# The Planning Inspectorate Yr Arolygiaeth Gynllunio

Our Ref: EN010112

### **Application by Awel y Môr Offshore Wind Farm Limited for an Order Granting Development Consent for the Awel y Môr Offshore Wind Farm**

#### **Advice following issue of decision to accept the application for examination**

Esri UK, Esri, HERE, Garmin, INCREMENT P, USGS

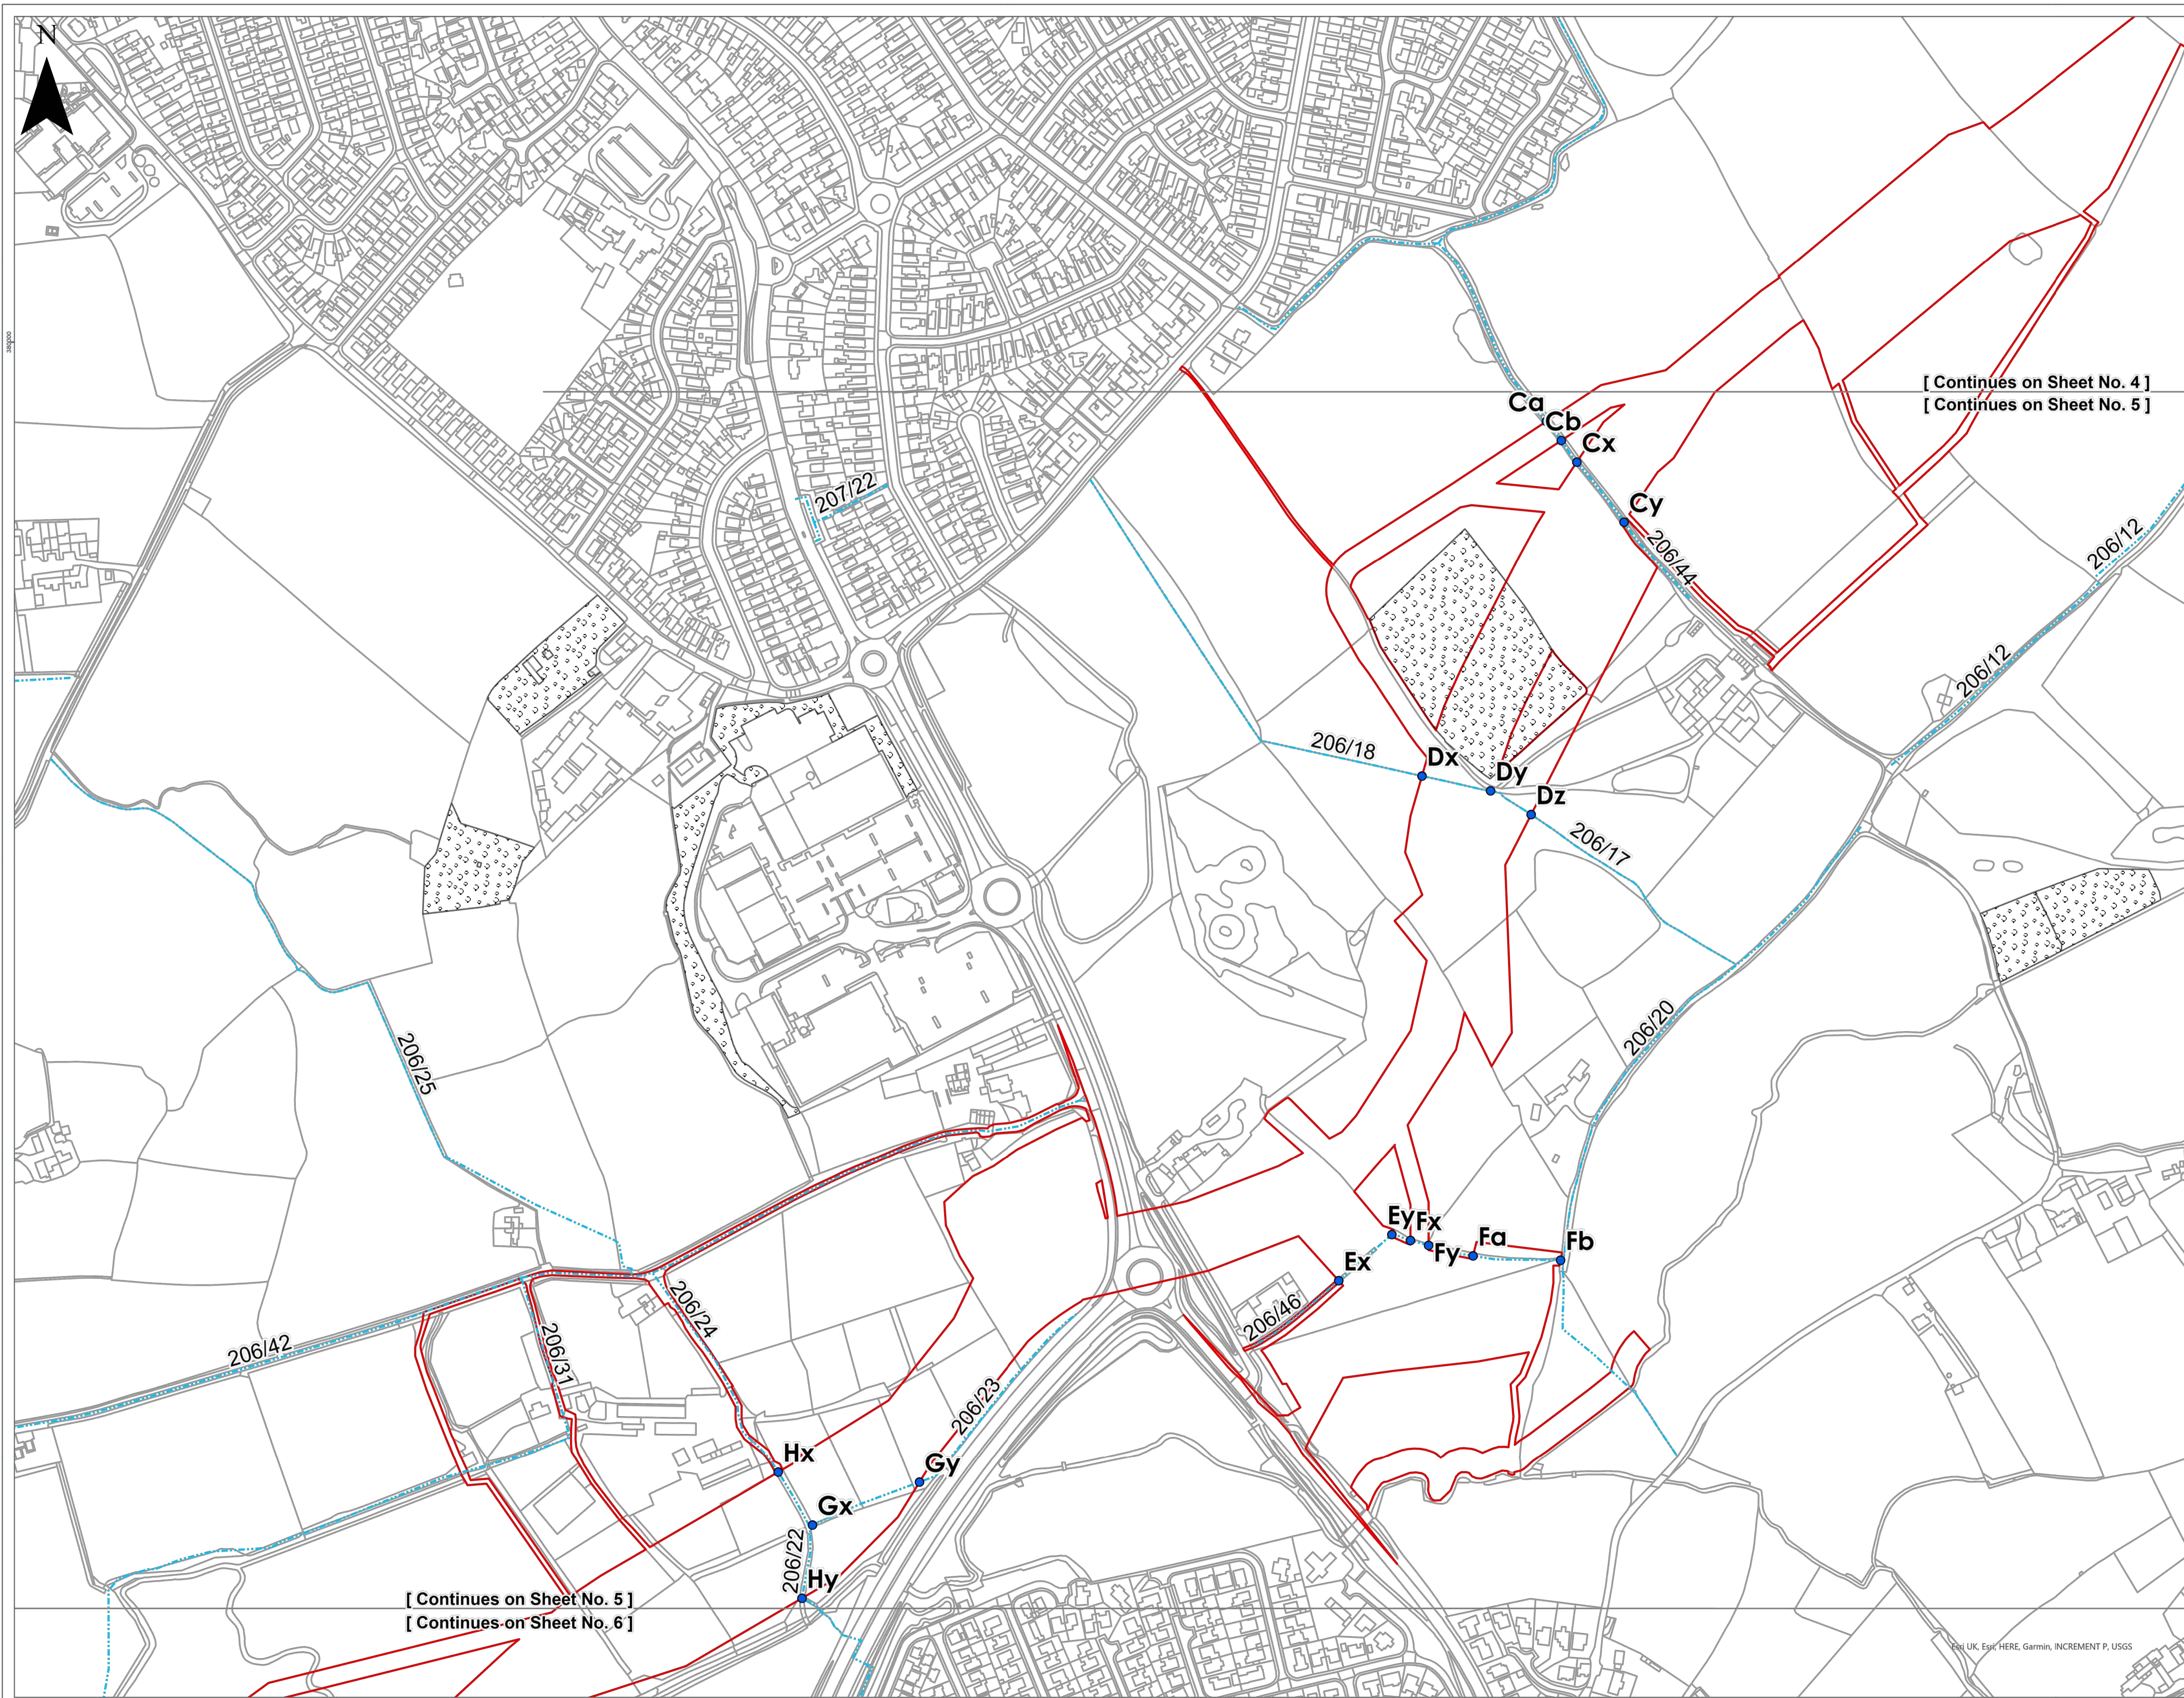
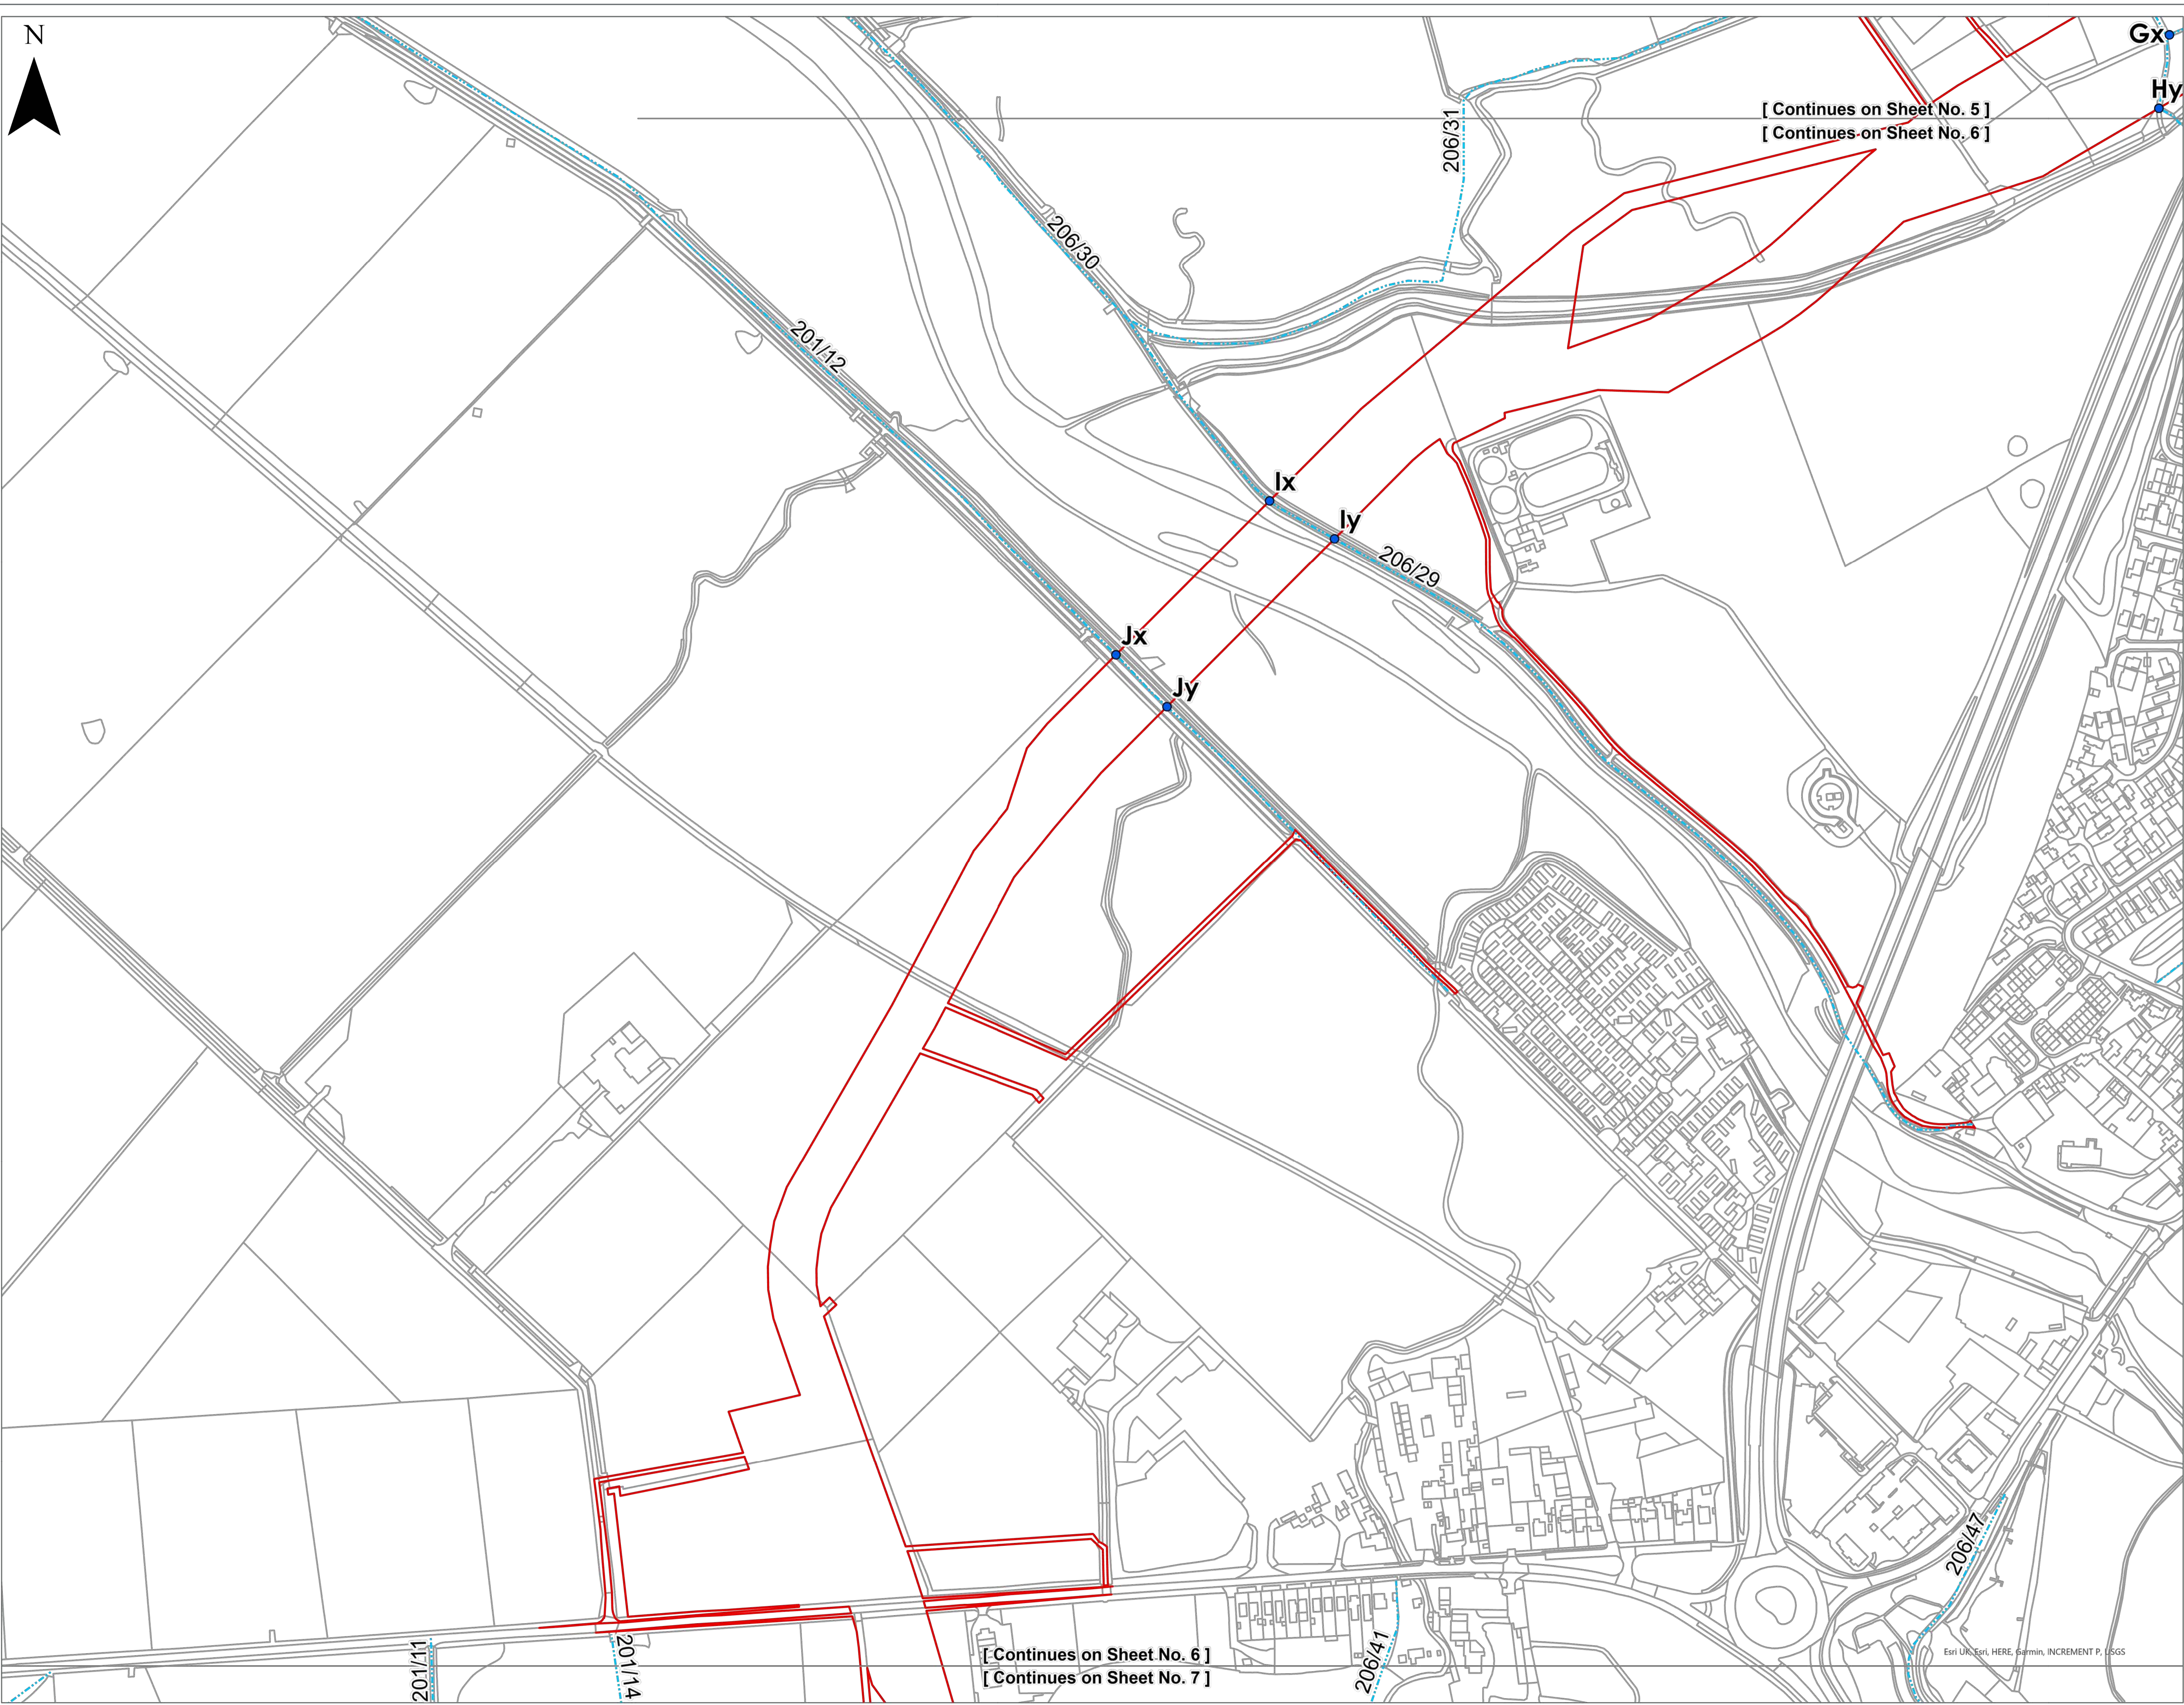
- The legend in the Street Works and Access Plan refers to Schedule 4 instead of Schedule 3 of the dDCO.
- Footpath names on the Temporary Stopping Up of Public Rights of Way Plans could be enlarged.

- Schedule 3 – points BI and BJ shown on the last page of the street works and access plan have been omitted.
- Schedule 4, columns 1 and 2 – inconsistencies between the information in these columns and the information shown on the temporary stopping up of public rights of way plan, and the naming of the plan is the 'temporary stopping up of public rights of way plan'.
